PHTV Comments added dated 30/1/17

DATE: 9th December 2016

SUBJECT: LU/234/16/RES - Application for reserved matters relating to access, appearance, landscaping, layout and scale of the previously approved LU/63/11/. This application affects a Public Right of Way.

LOCATION: Fitzalan Link Road, Worthing Rd (A259), East Street, Littlehampton, West Sussex.

rev.
P5

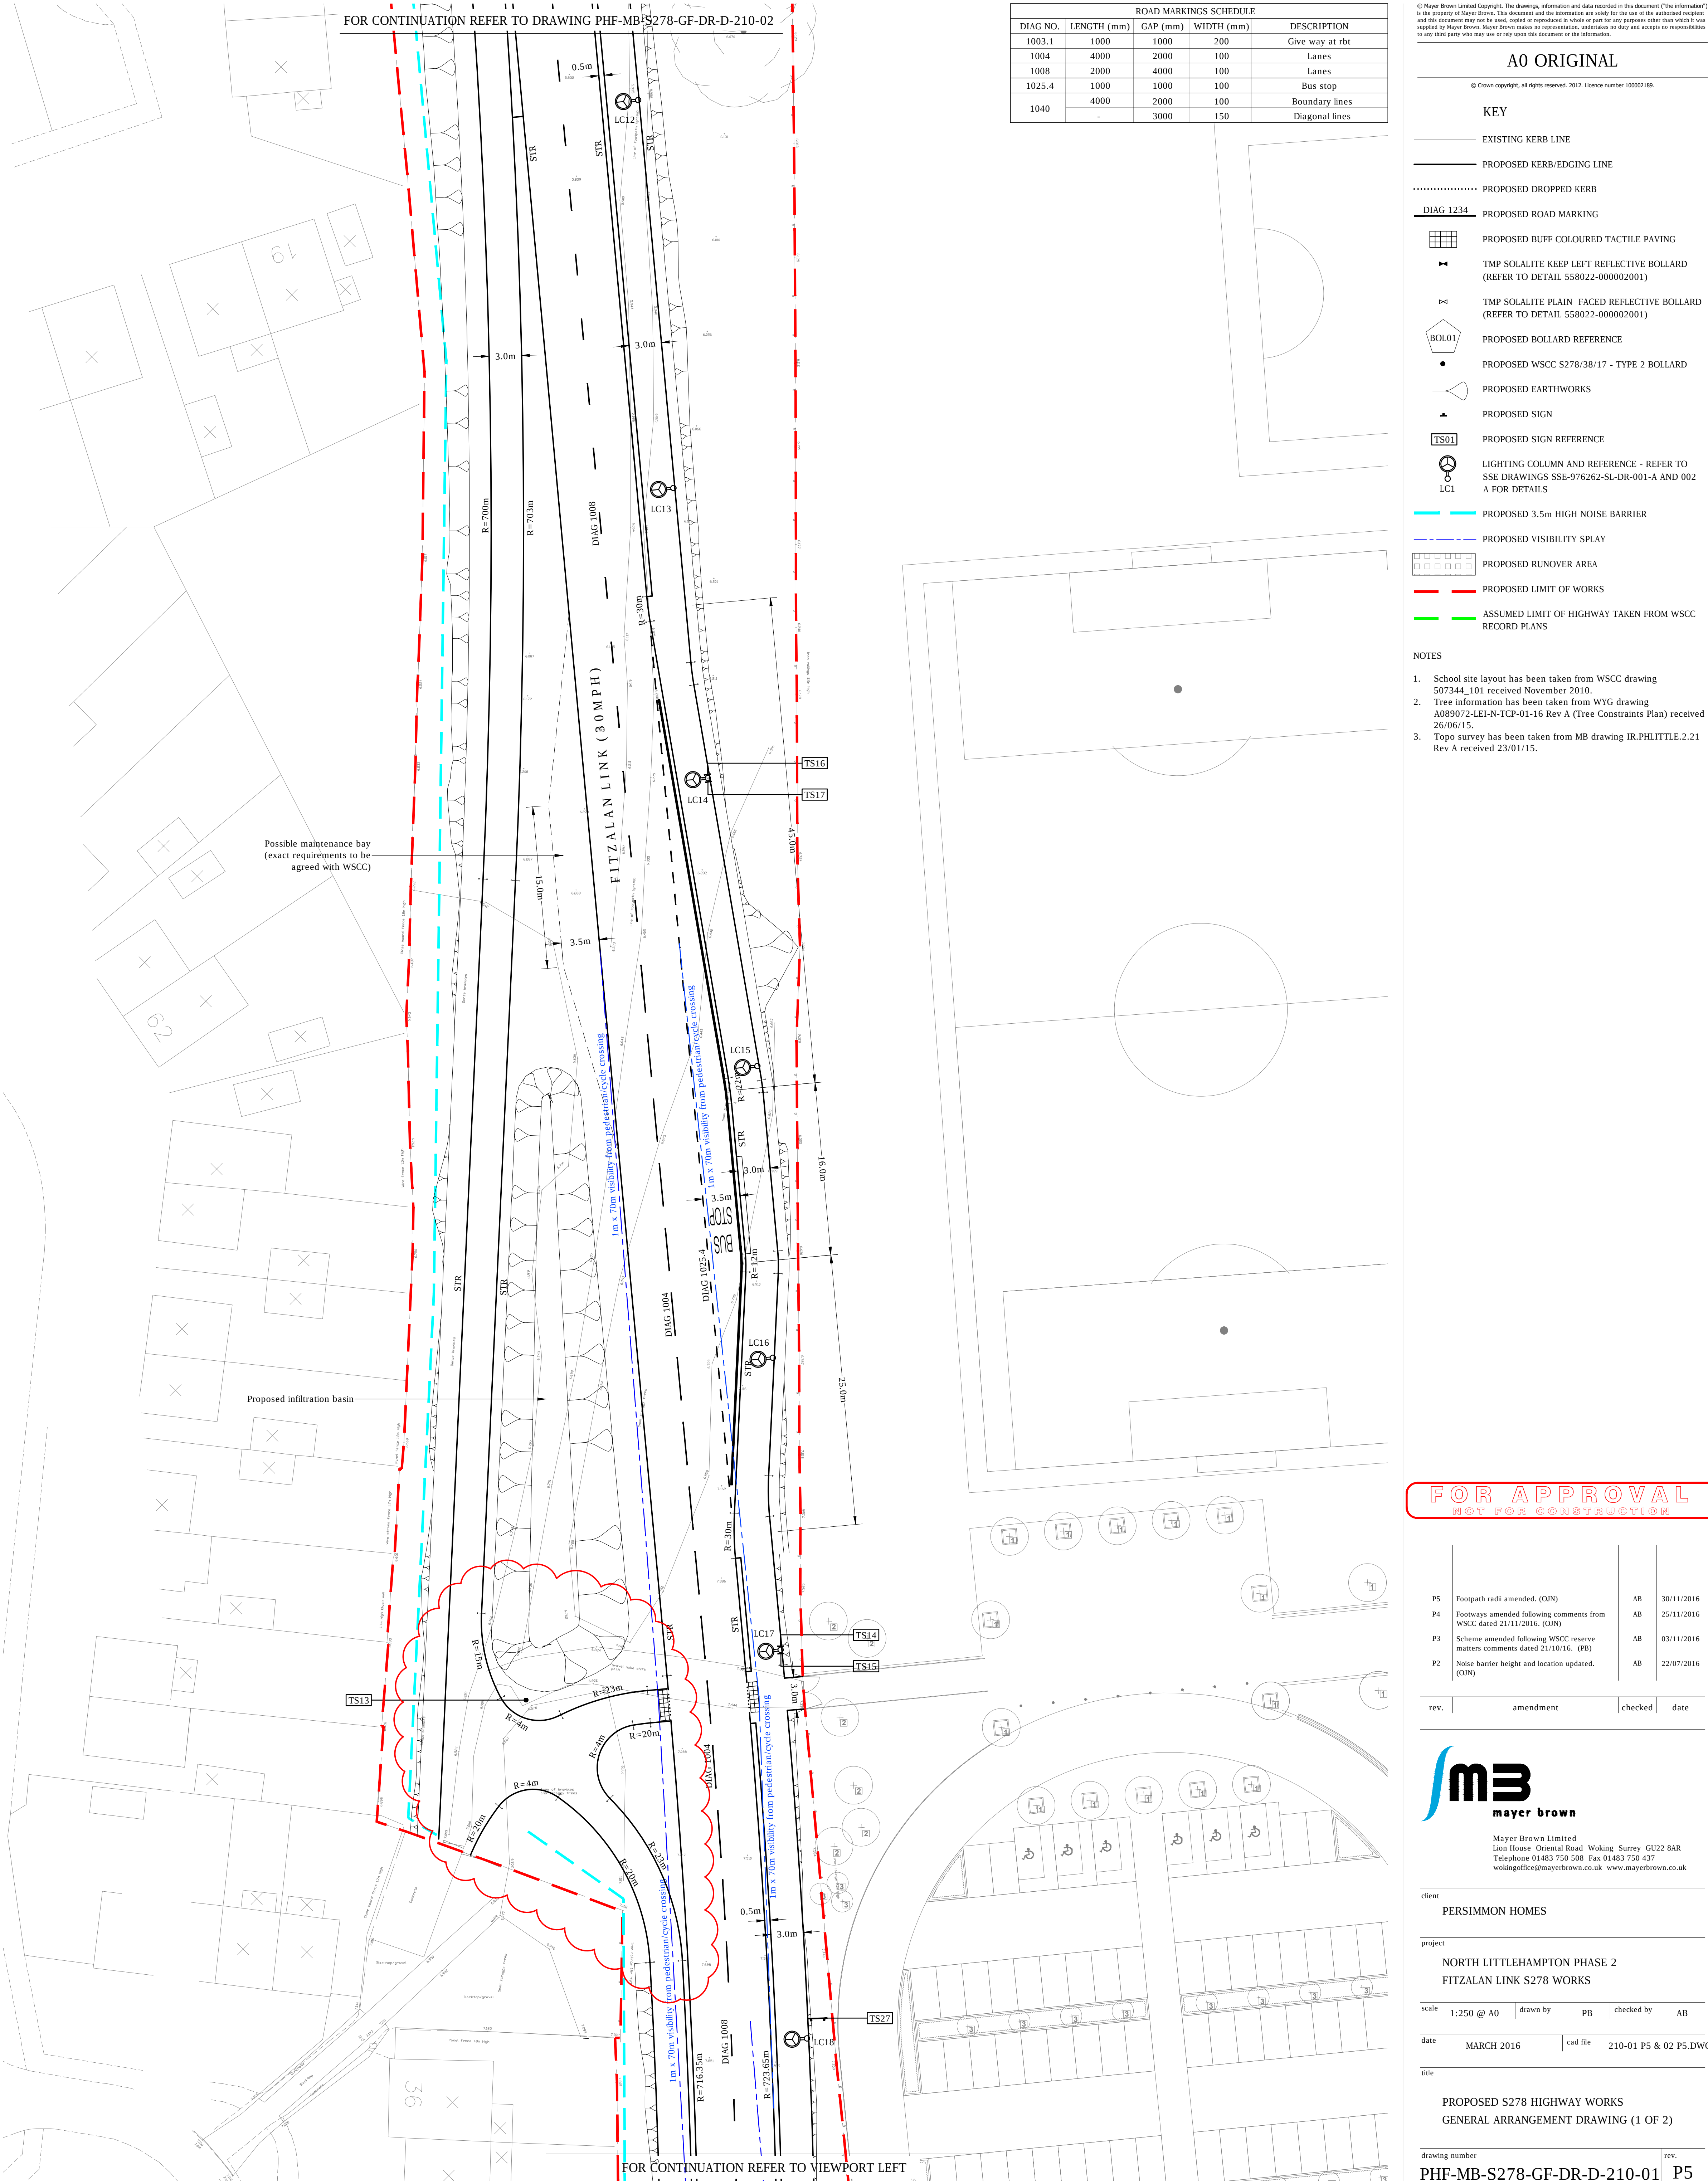
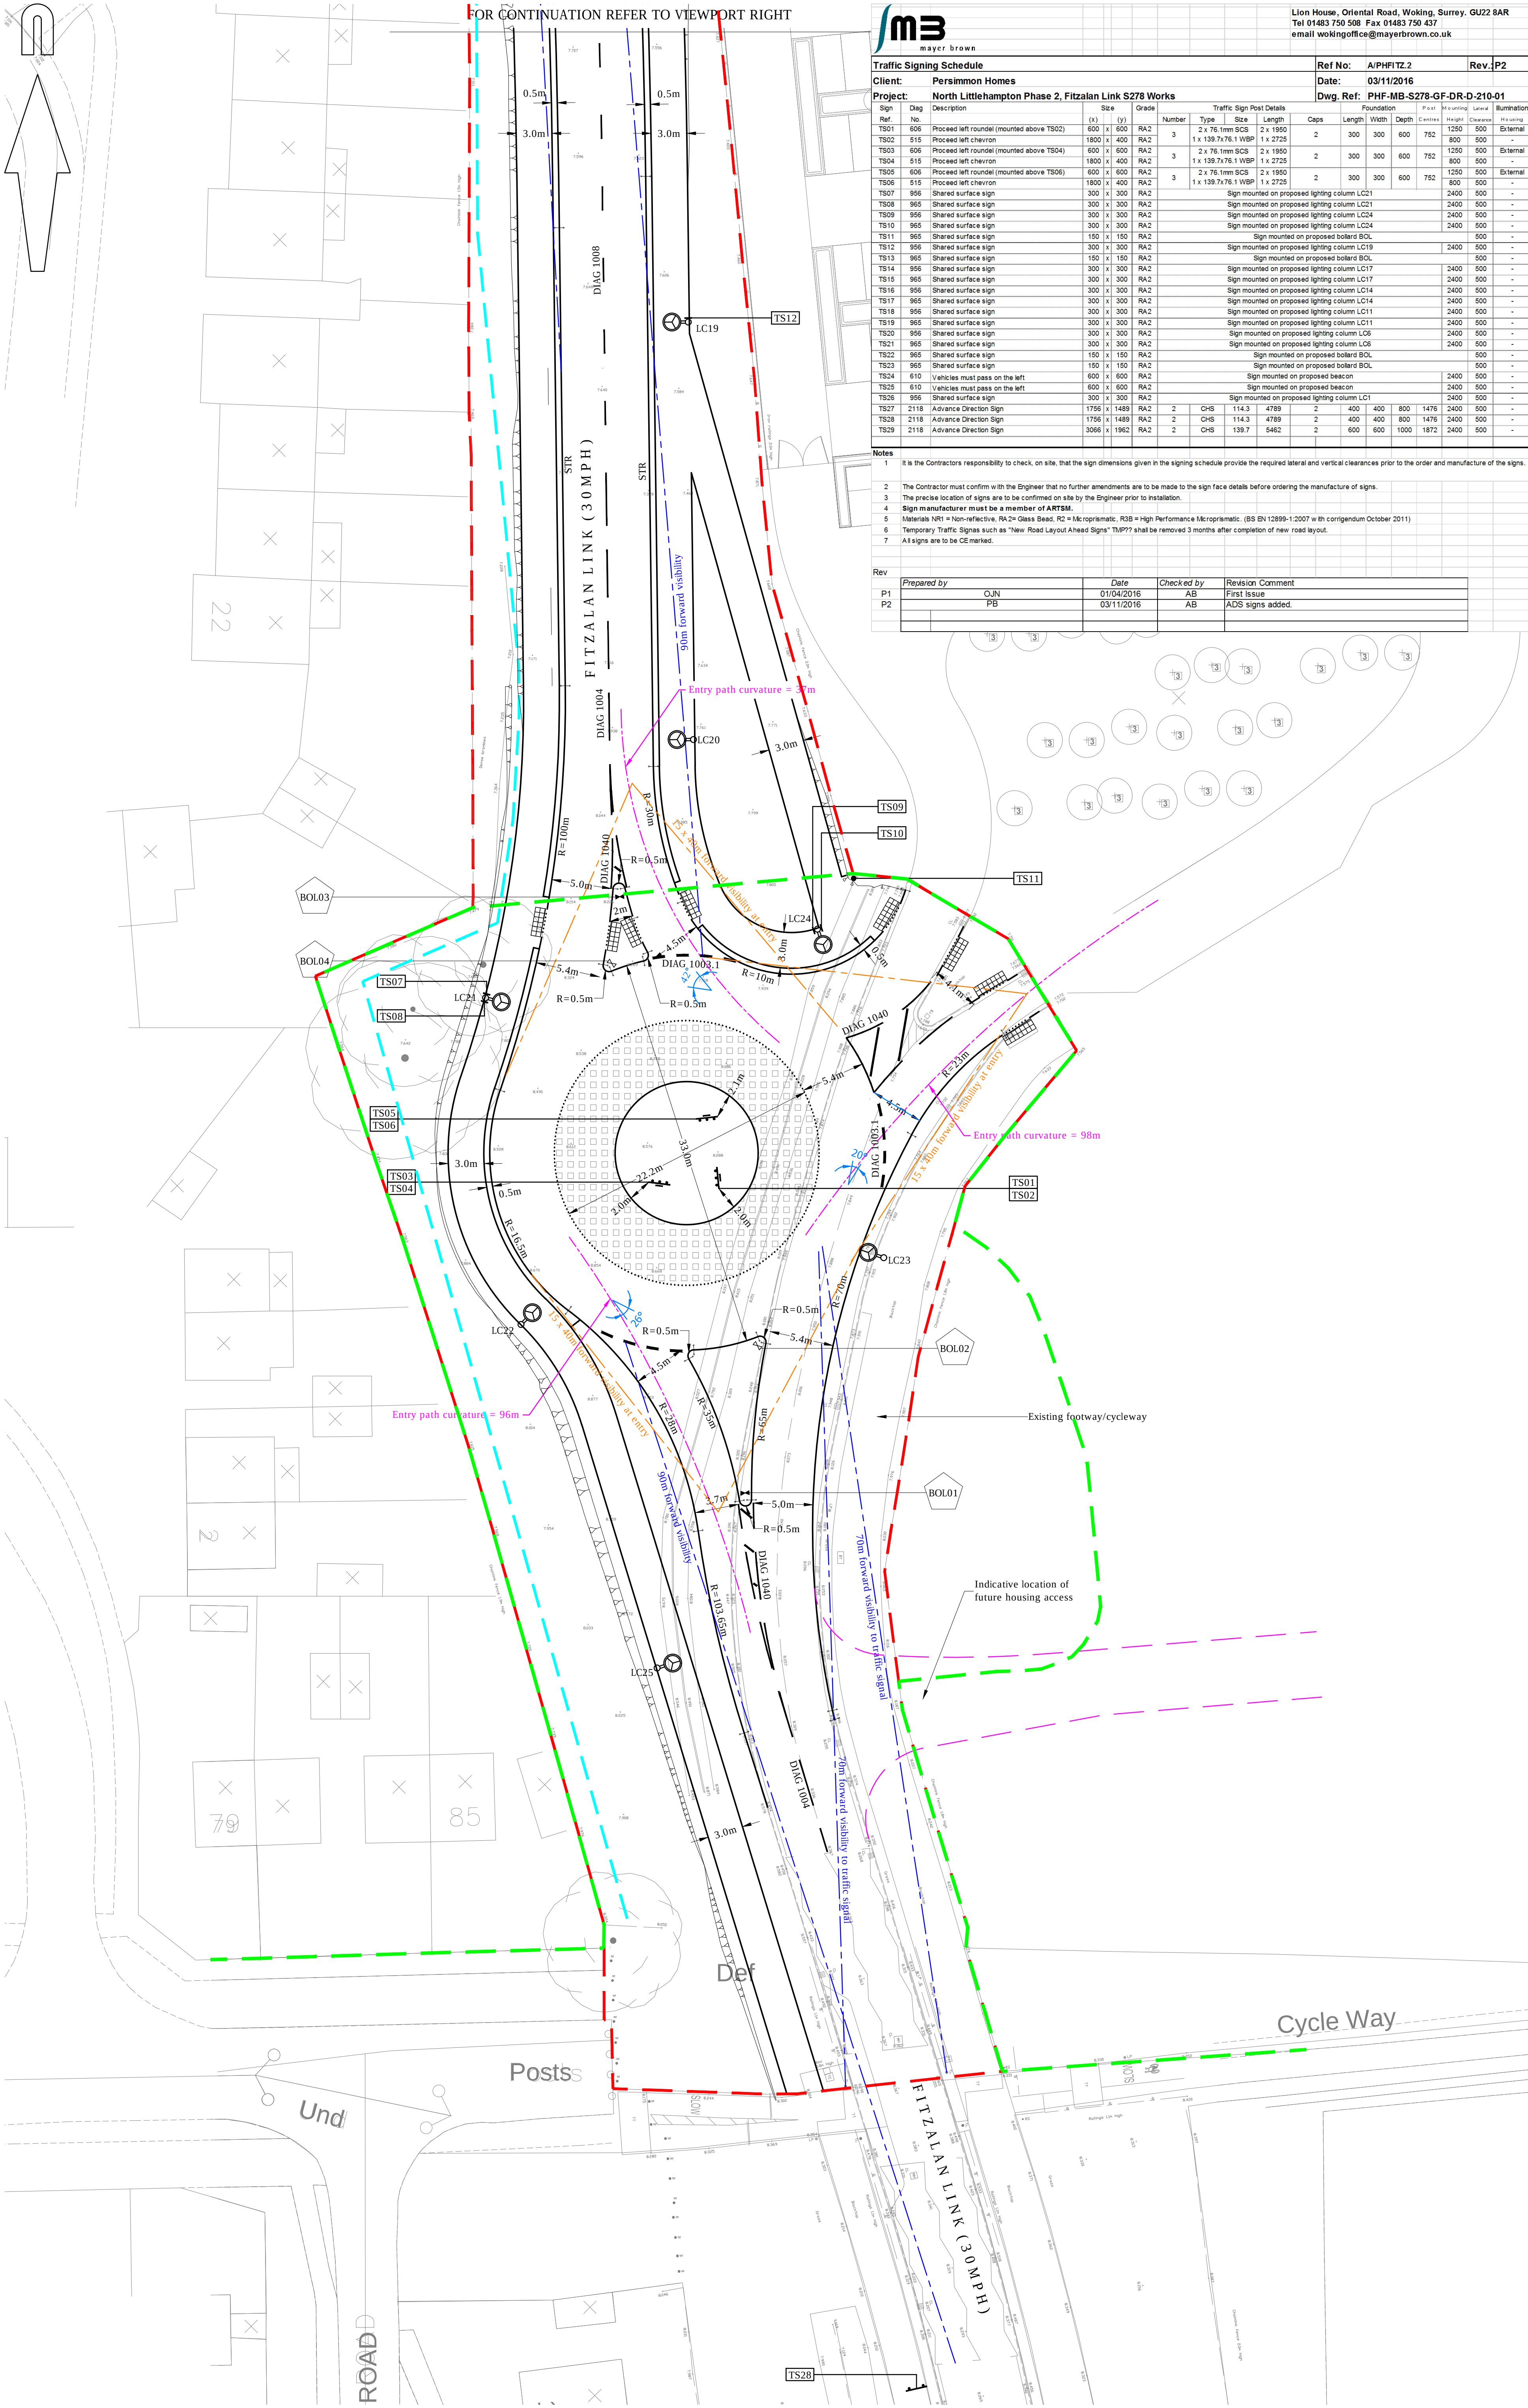
2. Bus layby south of Academy RBT – WSCC drawings for the section of road south of the Academy entrance do not appear to show the bus layby as suggested by the applicant. As such, this matter is not concluded and a further response is required from the applicant on the subject of a northbound bus layby. **Further information and alterations required.**

The approved WSCC drawings do not include a bus layby. As such, one is still required for northbound traffic to complement the one for southbound traffic. Please show.

4. Refuge adjacent to Highdown Drive – Applicant should demonstrate that adequate kerb-to-kerb width for vehicles is provided either side of the proposed pedestrian/cycle refuge and that the refuge itself is wide enough for pedestrian and cycle usage. The full WSCC specification for refuges can be found on the WSCC website. Further information and alterations required.

The lanes must have minimum kerb-to-kerb widths of 3.5m each side of the refuge or similar kerbed upstand and/or feature. Please amend.

10. Maintenance access and access routes to be identified alongside road (to permit vehicles to be parked clear of the road when maintenance is taking place) – Please show.

The layby arrangement shown opposite the southbound bus stop would not be acceptable as it would be parked on and generally likely used in a detrimental way. As such, a short section of kerbing with angled/bevelled kerbing and an area of grasscrete should be provided at a suitable location for maintenance vehicle purposes. This should be indicatively shown on a revised drawing now for planning purposes with final details being checked/agreed at the S33/278 stage.

Accepted. The design has been amended to incorporate a pedestrian refuge island as required by WSCC detail numbered S278/38/19 Rev B with 3.2m lane widths, 2.5m wide island and road markings offset from the island, as requested. Please refer to amended drawings PHF-MB-S278-GF-DR-D-210-02 Rev P5.

Accepted. Kerb-to-kerb width is 3.5m as requested. The 3.5m dimension shall be added to the drawing for clarity.

Accepted. A short section of kerbing with angled/bevelled kerbing and an area of grasscrete shall be provided at a suitable location for maintenance vehicle purposes. This shall be indicatively shown on a revised drawing, as requested.
